Application by Drax Power Limited for an Order Granting Development Consent for the Drax Bioenergy with Carbon Capture and Storage Project

Request for further information

Questions under EPR Rule 17 (R17QB)

Issued on 22 June 2023

### Proposed Changes to Land Plans for OHL1

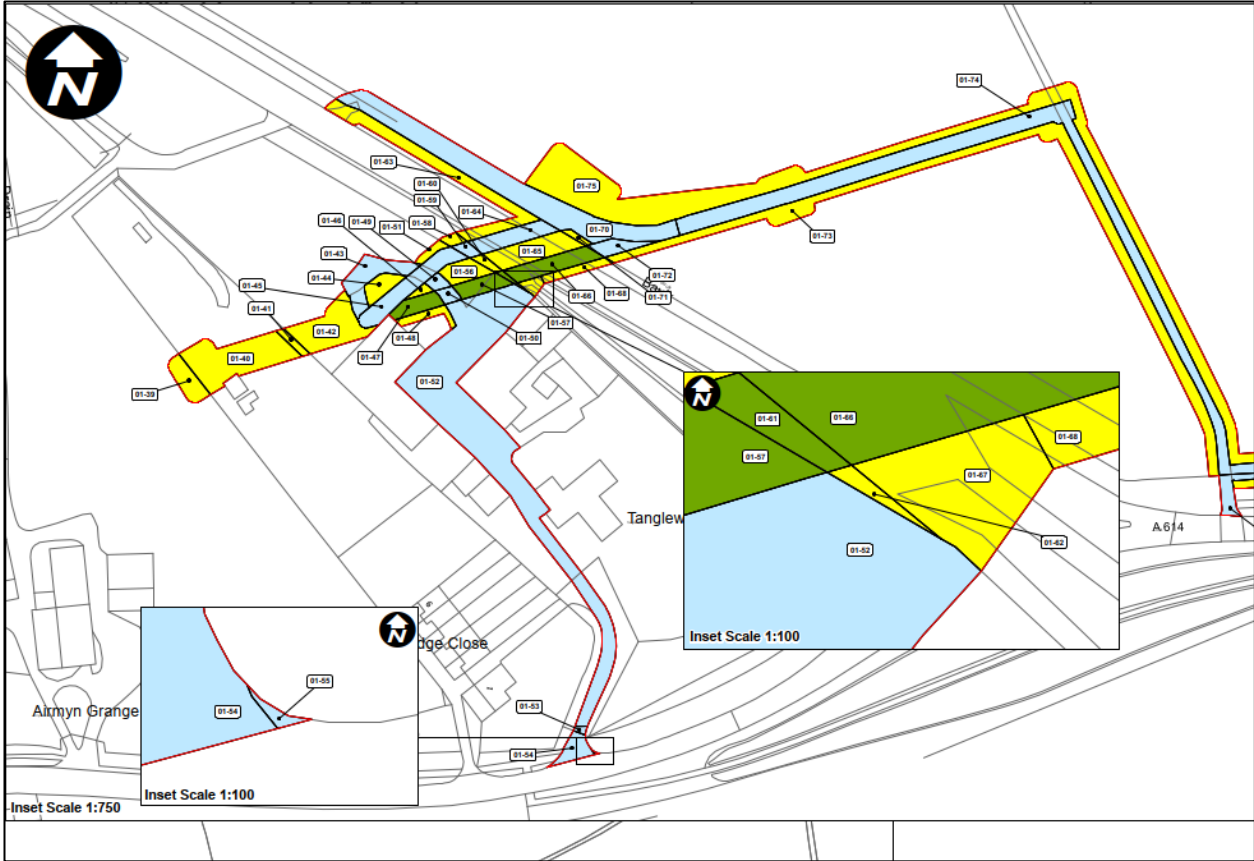
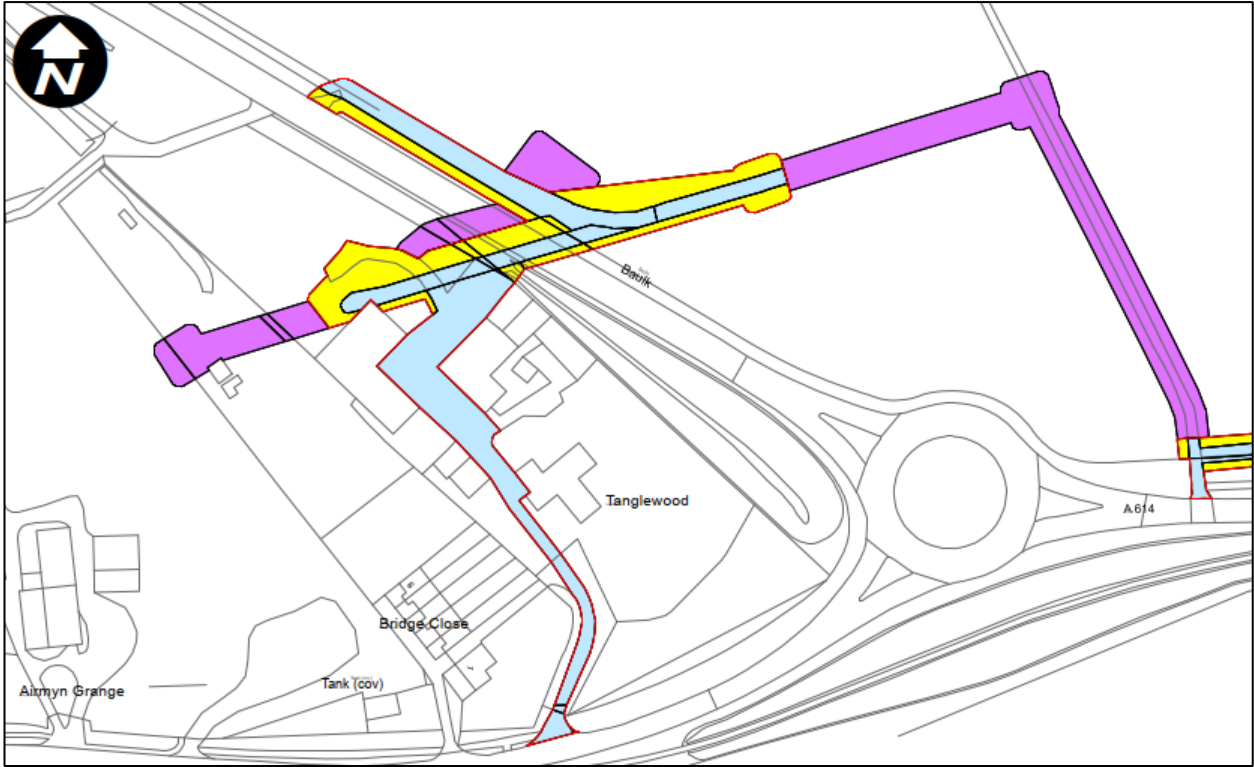
R17QB	Question to:	Question:
R17QB.9	Applicant EA NE NYC	<p>Applicant:</p> <p>a) Whilst the ExA notes the requirement set out in the Applicant’s Response to R17QA.21 [REP8-029] has been put forward without prejudice, please provide a detailed explanation of what this requirement would achieve and how it would work in practice.</p> <p>EA, NE and NYC:</p> <p>b) Please provide comment on the Applicant’s suggested requirement as set out in the Applicant’s response to R17AQ.21 [REP8-029] which would, amongst other things, prevent the authorised development commencing until development consent for the pipeline, the licence for the storage and the EP for Work No.1 was in place.</p>
DESIGN, LANDSCAPE AND VISUAL		
R17QB.10	ERYC	<p>The SoCG between the Applicant and ERYC submitted at D8 states in relation to the Design of Proposed Works OHL1, OHL2 and TCL1 that: <i>“Following the online meeting on 02 June 2023 between ERYC, WSP and the Applicant, ERYC will review the Second Change Application and provide any comments via relevant representations where necessary.”</i></p> <p>As no Relevant Representation on the Second Change Application was received from ERYC, ERYC is asked to detail any remaining concerns they have regarding the following:</p> <p>a) Cable route and depth; b) Soil management; c) Field drainage; d) Future rights; e) Works compound and access; and f) Impact of undergrounding telecommunication line.</p>
